Application for a non-material amendment following a grant of planning permission.

PROPOSED GROUND FLOOR

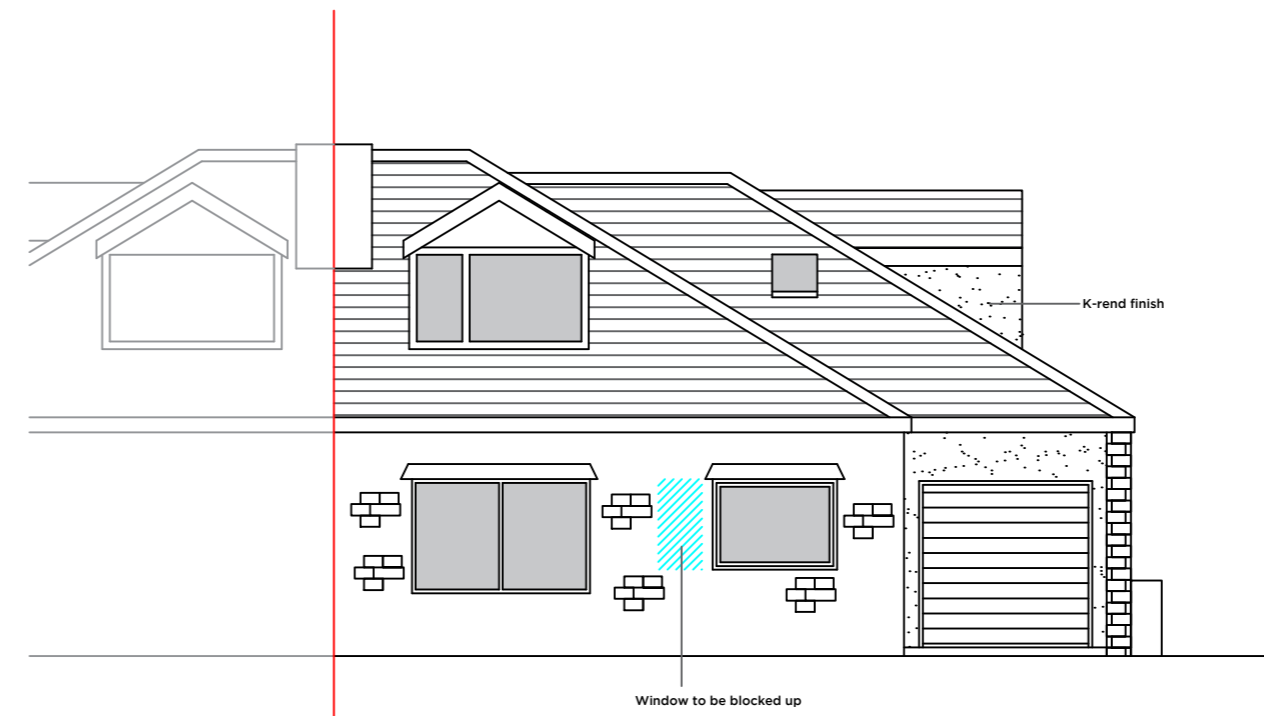
- Proposed rendered finish to cheeks of front and side dormers
- Proposed reduction in width of garage from 3.3m to 3m.
- Proposed infill of small window to front elevation
